From: Mark Edwards [REDACTED]
Sent: 02 February 2024 14:29
To: Andrew Thompson
Subject: FW: Northcote Road, Langho (Application no. 3/2022/0537)

We have been asked by Oaktree Developments to review the visibility splay requirements for the approved 8no. dwelling residential scheme on Northcote Road in Langho.

client: oak tree developments
project: northcote road, langhol
project number: J327909
scale: 1:250@A3
drawing title:
visibility splays based on 85th percentile speeds
drawing number:
J32-7909-PS-001

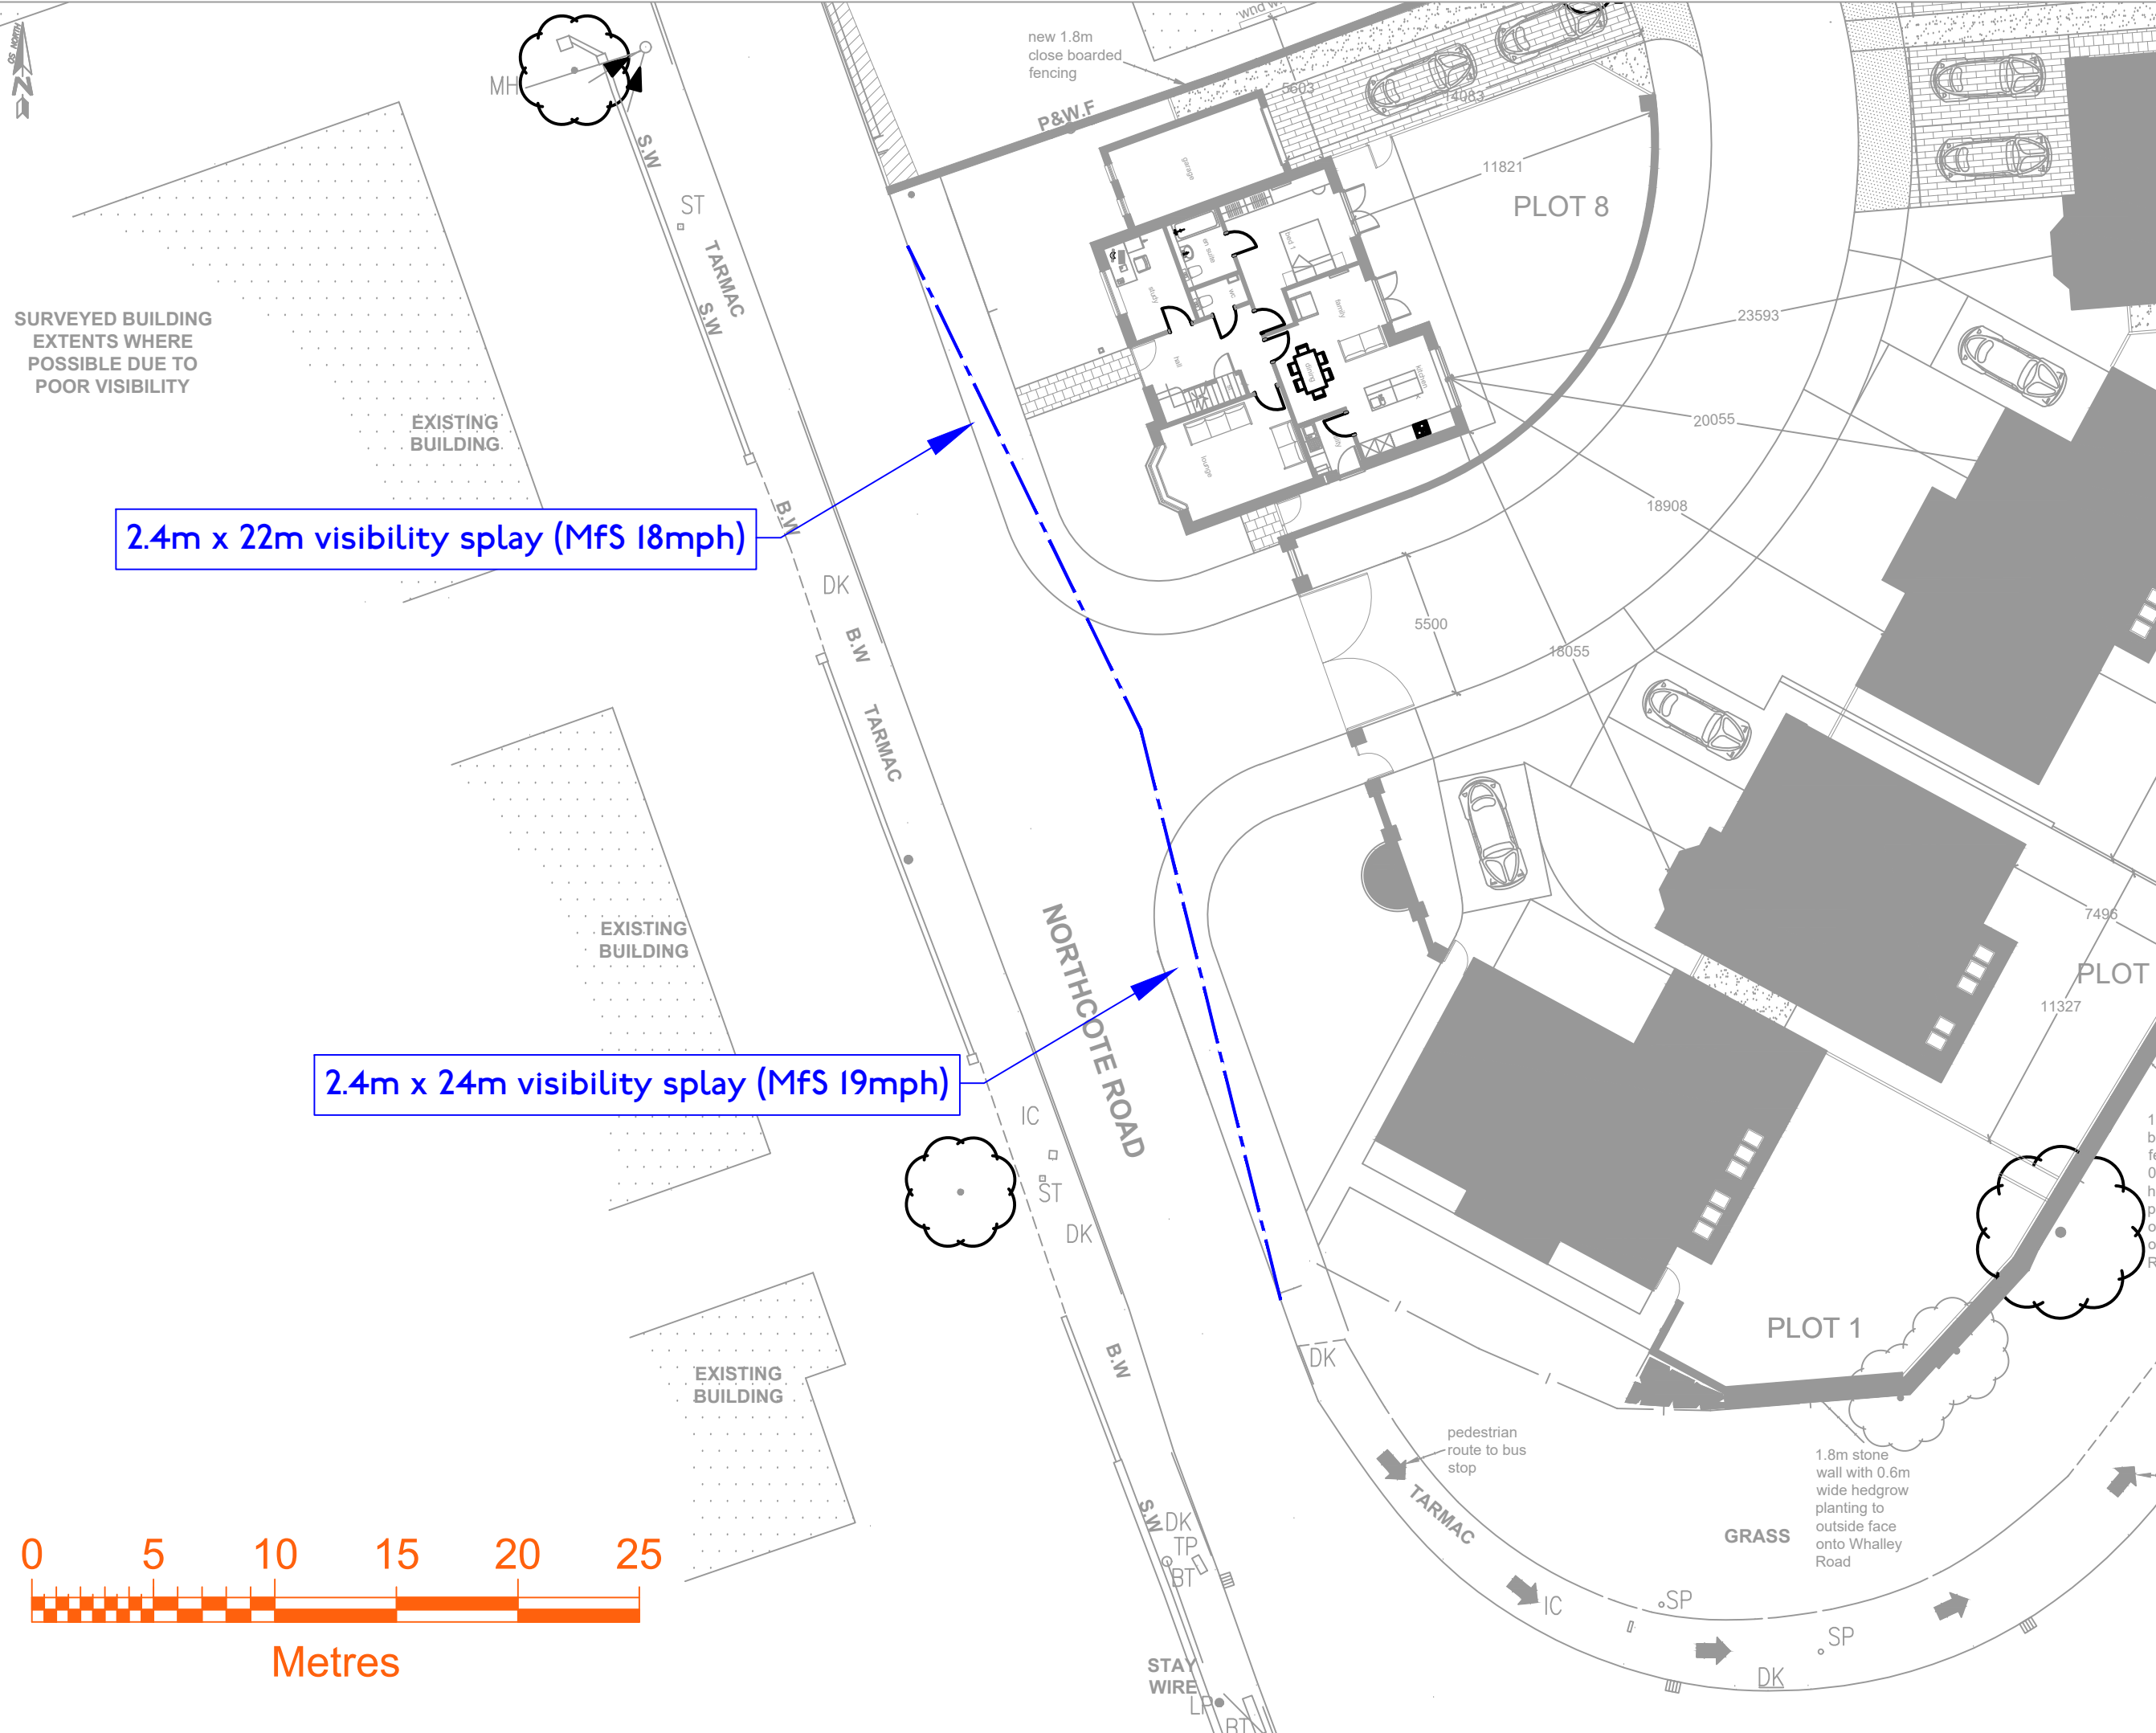
If you can submit the data for the ATC and provide a visibility splay drawing which shows that the access can provide the required visibility splays following the submitted 85th percentile speeds, the LHA would have no objection to the variation of condition.

I am happy with this.

If you can submit all the information you have sent me to support the planning application so it is in the public domain, the LHA will have no objection to the variation of condition application.
